Planning Services Sign Permit Review Form

Date of Submittal	Application Number	Applicant	Landowner
9/01/2025	SIGN2509-0006	Design Element of NC	Mark Altman / Davidson Homes LLC

Reviewed By:	Date of Review	Review Results
Randy Baker	9/19/2025	☐ Approved ☒ Denied

**RETREAT AT NORTH MAIN
OVERALL SITE LAYOUT**

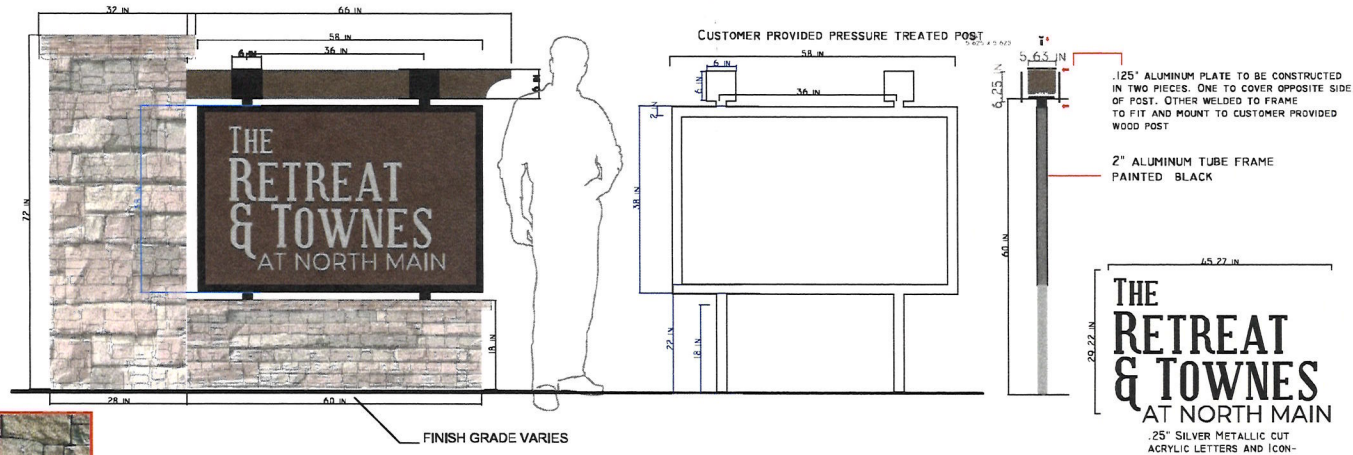
Comments	In cases where signs are placed at intersections, the minimum setback shall be 20 feet as measured from each right-of-way line or property line in both directions.
----------	---
